17 July 2018  
Annie Leung  
Team Leader, Key Sites  
Assessments

SYDNEY METRO: OVER STATION DEVELOPMENT  
VICTORIA CROSS, NORTH SYDNEY  
SSD 8874

**Figure 5:** Proposed Victoria Cross OSD building envelope

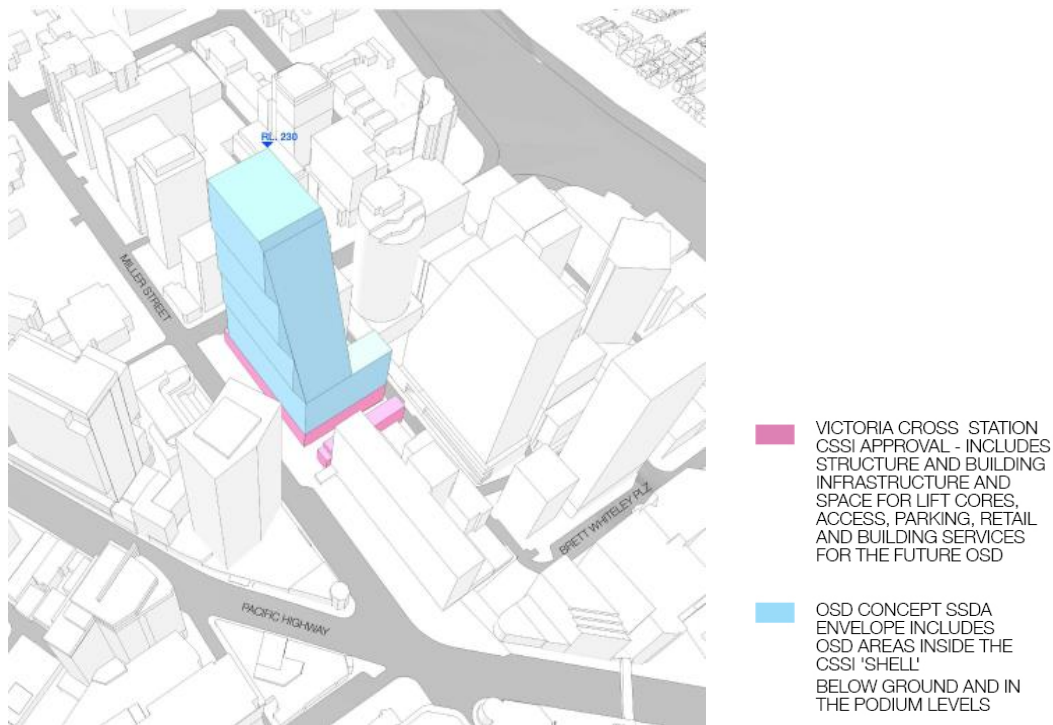
The proposed building envelope may have impacts on adjacent buildings, including apartments. Further study is recommended to ensure negative impacts are minimized.

The proposed building envelope includes architectural features and modelling which are not considered relevant at Concept Stage. Architectural details should be informed by further design development and provided for review as part of any Stage 2 Development Application.
